Mr Haakon Nielssen
Manager Environment
Tronox Mining Australia Ltd
375-381 BENETOOK AVENUE
MILDURA VIC 3500

20/12/2019

**Snapper Mineral Sands Mine Modification 7 (MP06_0168 MOD 7)
Request for Submissions Report**

Figure 4

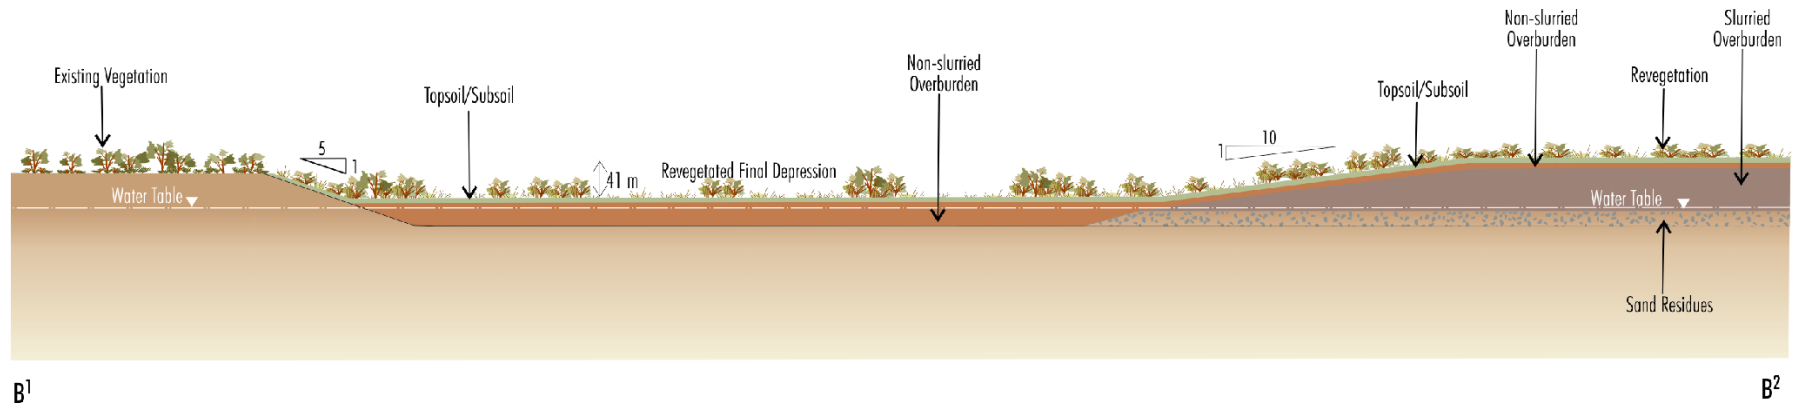
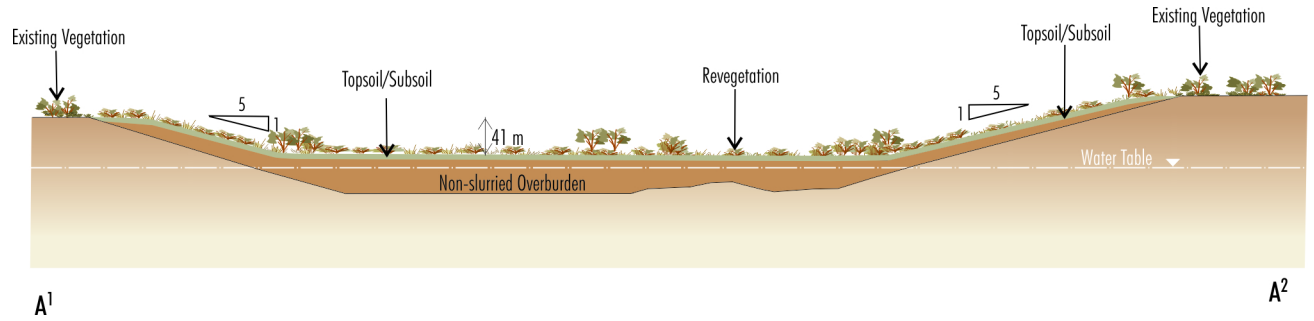
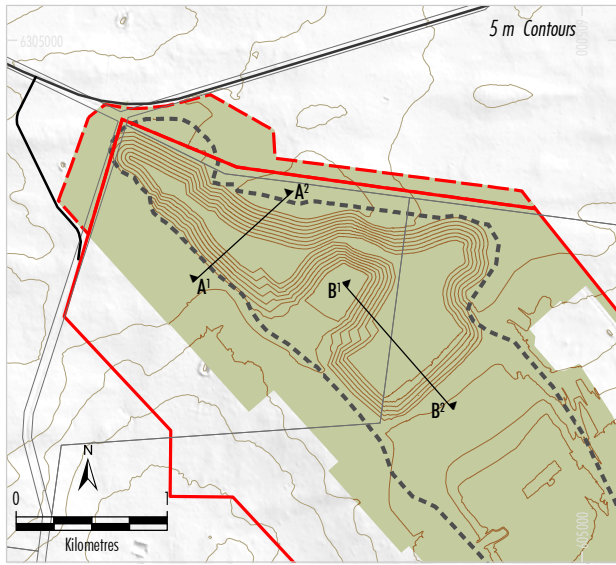
- Estimate the change in depth, volume, area and drainage catchment of the final depression, compared to the approved final depression.
- Confirm whether the batter slopes of the final depression would remain at a 1:7 grade, as per the existing approved Mining Operations Plan.
- Provide a scale for the section diagrams in Figure 6. The increments of the contour lines should also be provided.
